STATEMENT OF RESPONSE

Coastal Quarter SHD 2 Planning Application

IE000468
Coastal Quarter SHD, Bray
F01
14 September 2022

Purpose	PLANNING
Title	VEHICLE TRACKING ORCHARD EXISTING UNDERGROUND IRISH WATER FOUL STORAGE TANK
Original Scale	1:250 at A1 1:500 at A3
Design/Drawn	AK
Checked	CF
Authorised	KB
Date	19.08.22
Date	19.08.22
Date	19.08.22
Status	P
Drawing Number	5214419-ATK-01-ZZ-DR-CE-0126
Rev	P01

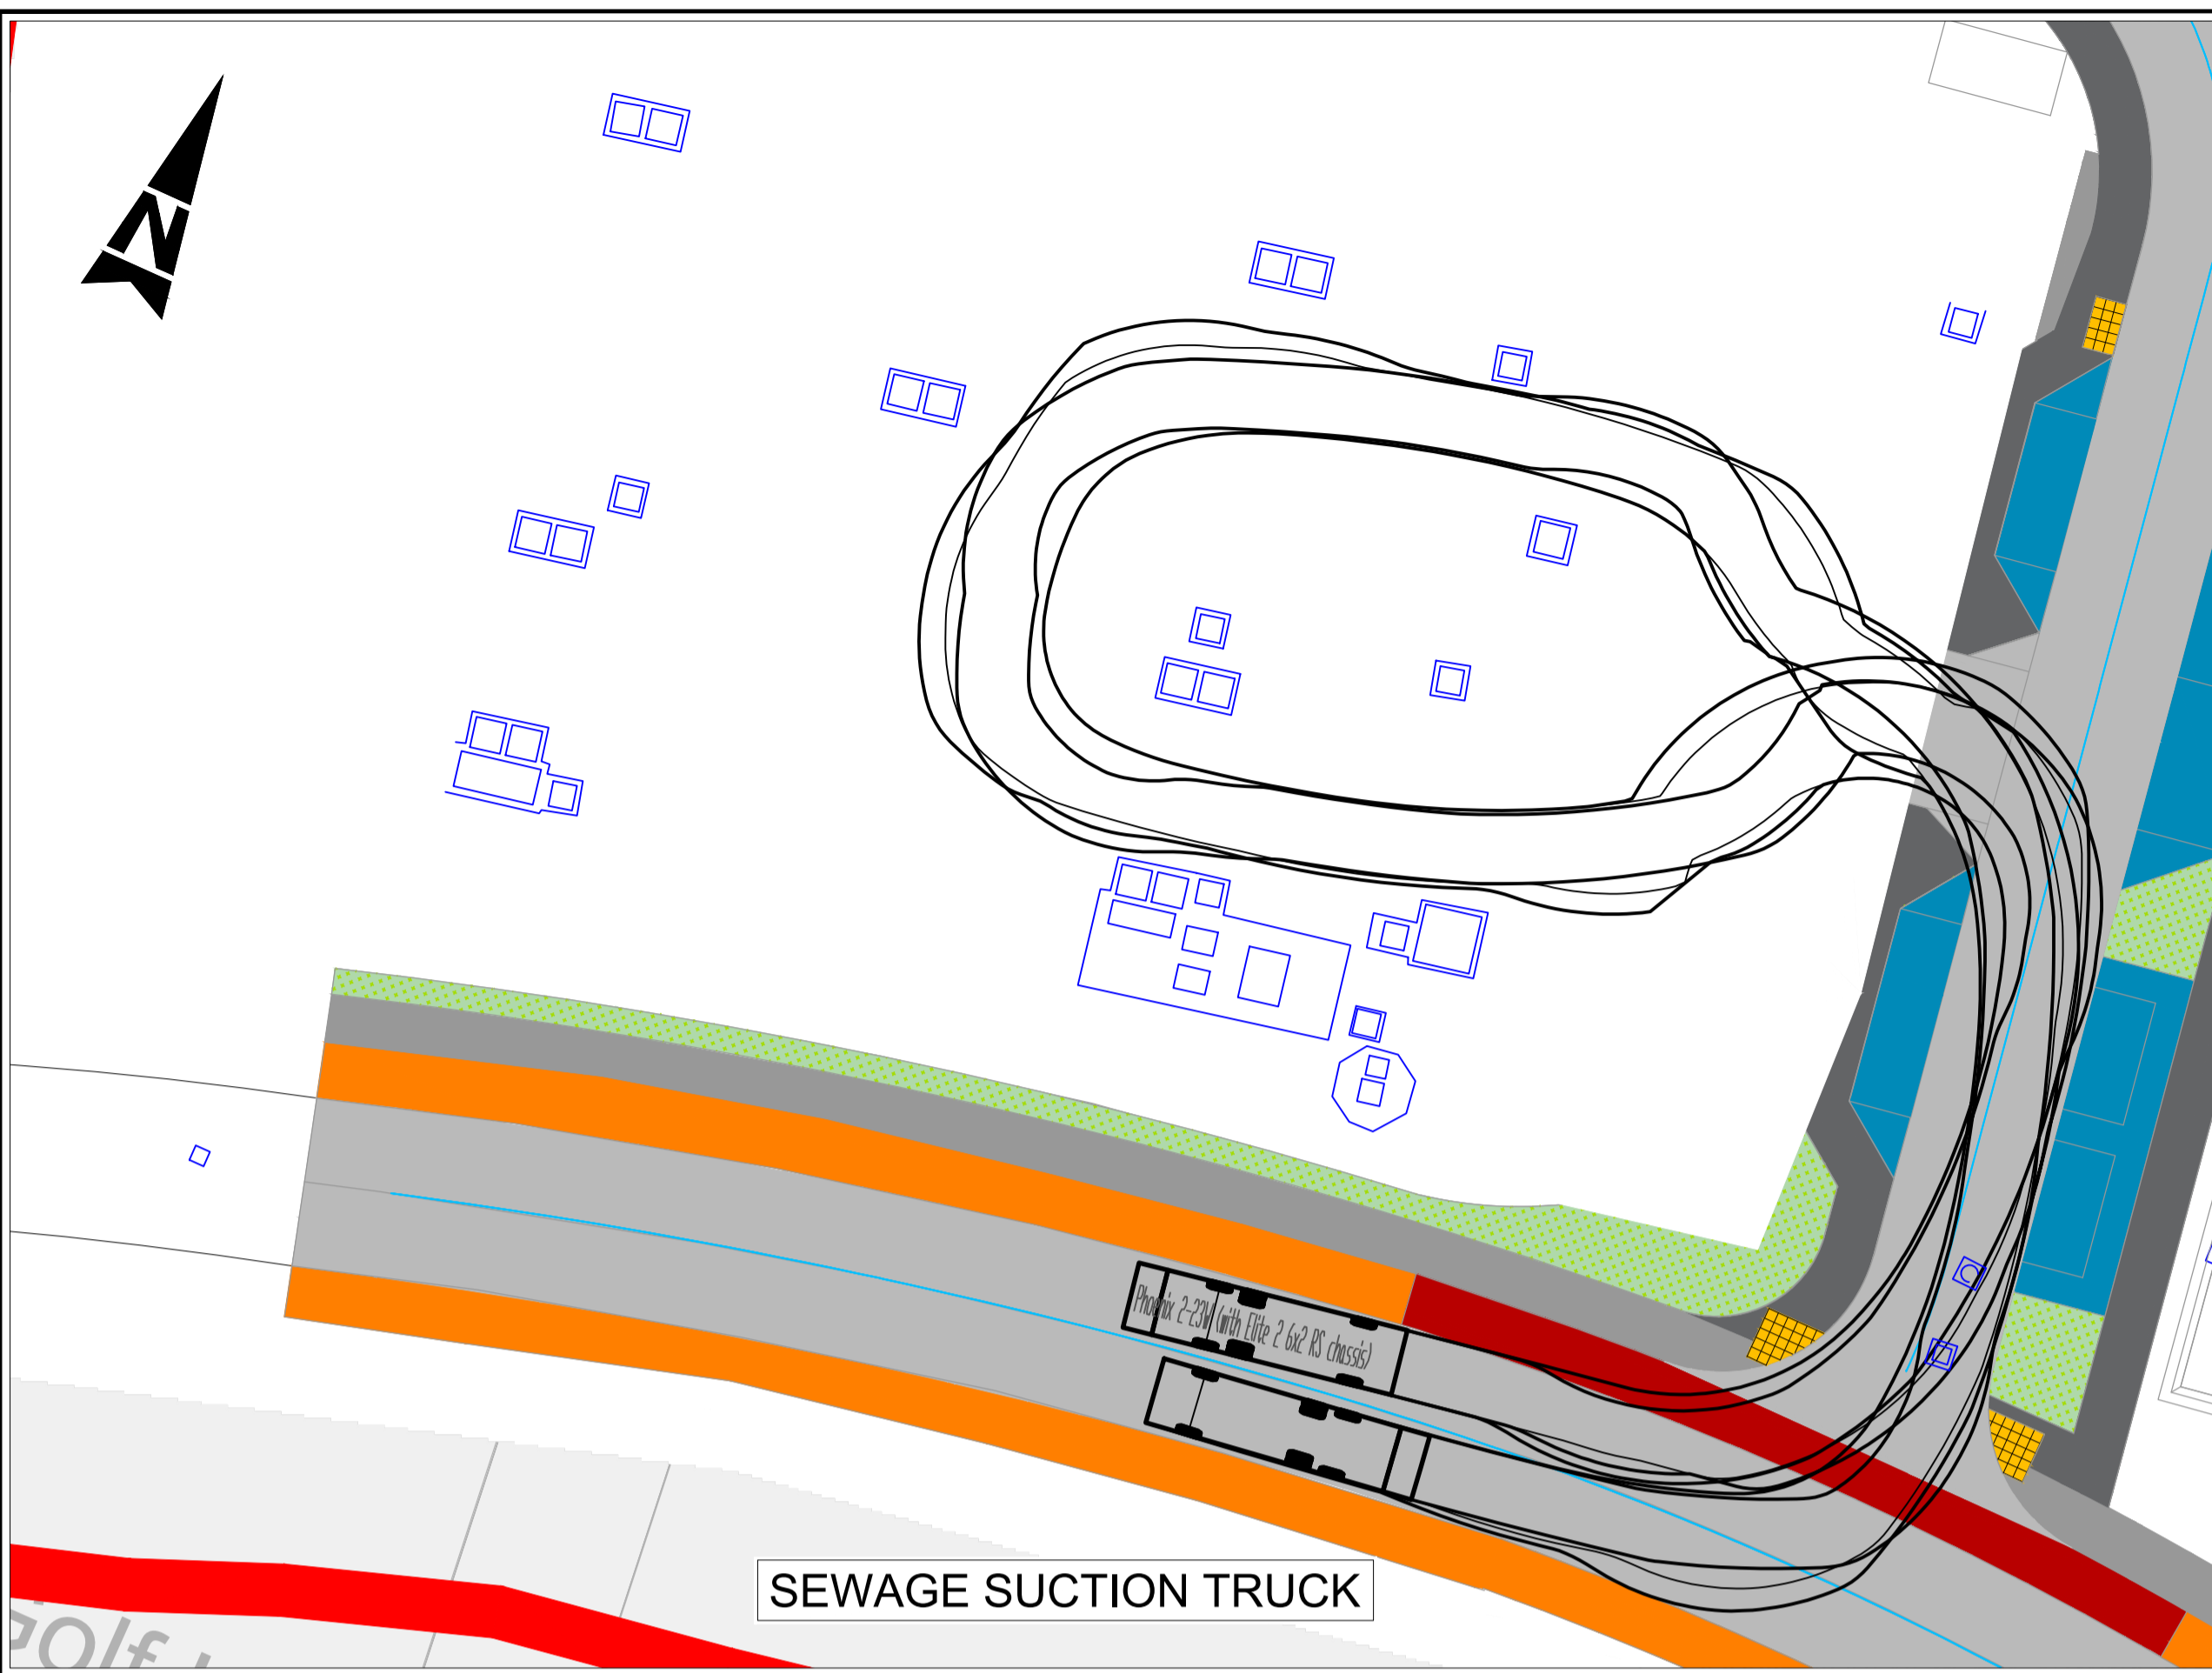
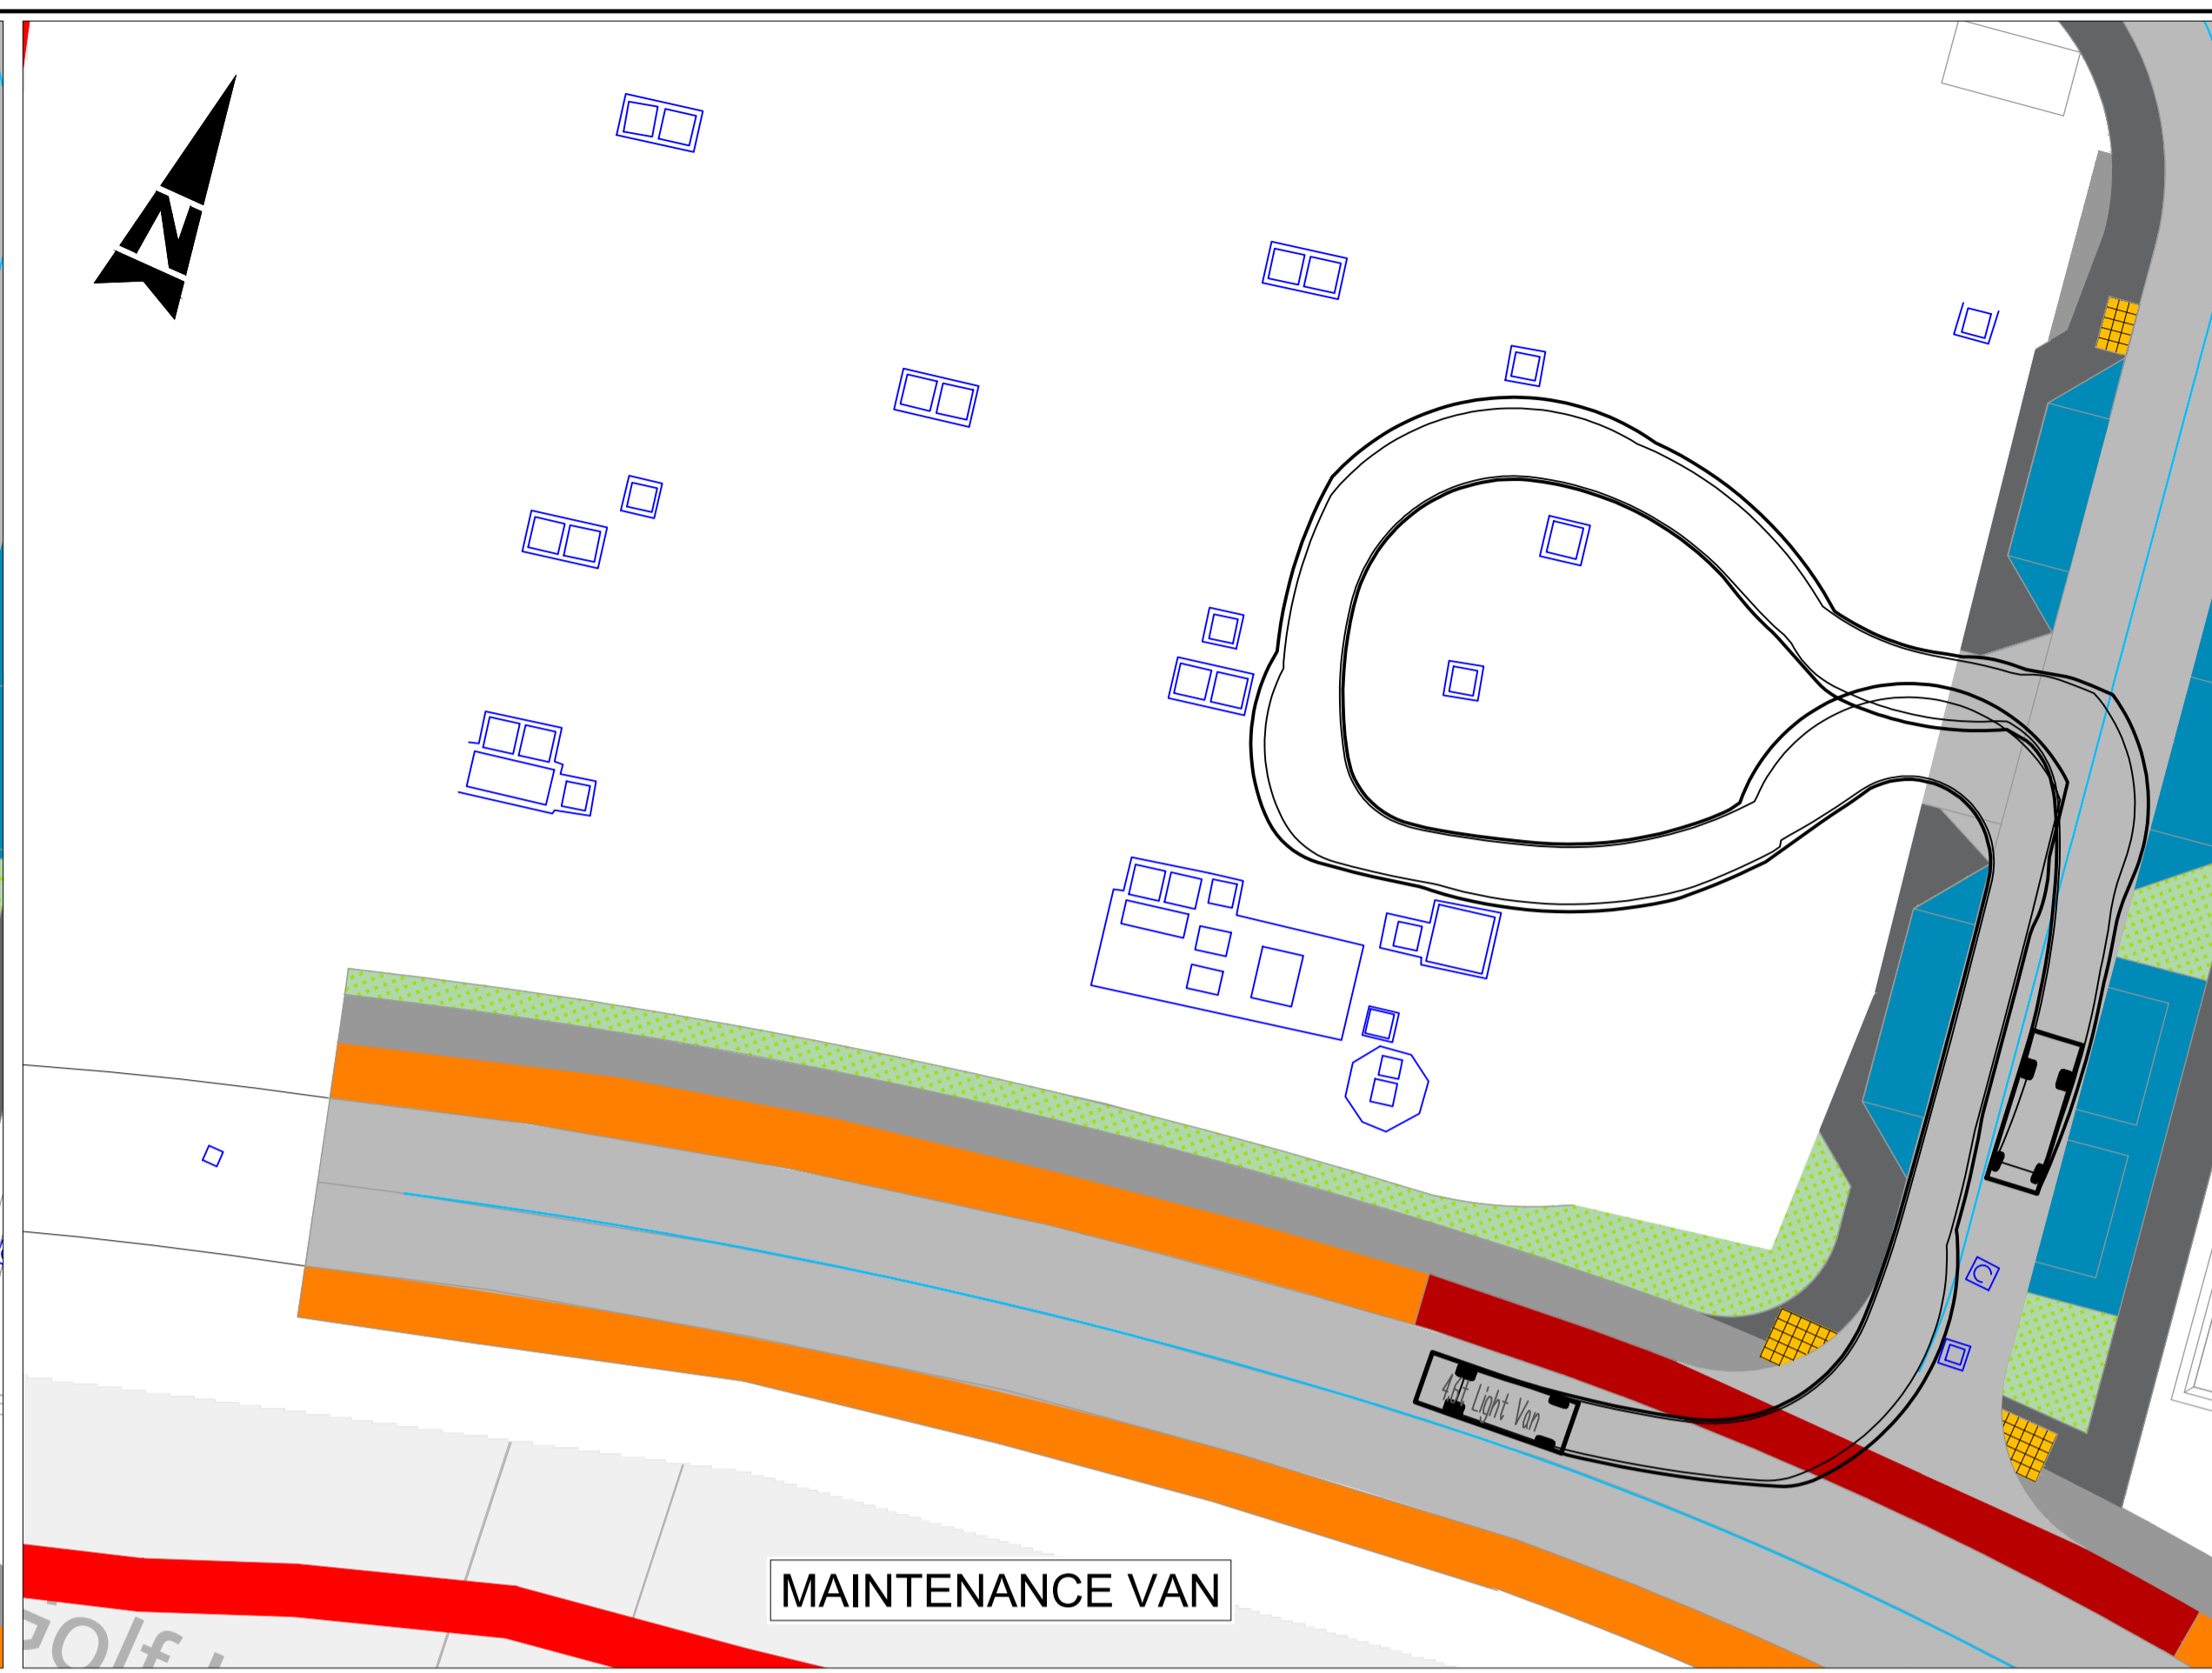
- *“The Applicant shall submit details which demonstrate the justification and purpose of the proposed overflow car park within the Orchard Area which contains 54 No. car parking spaces.”*

It is no longer proposed that car parking spaces be provided in the Orchard Area.
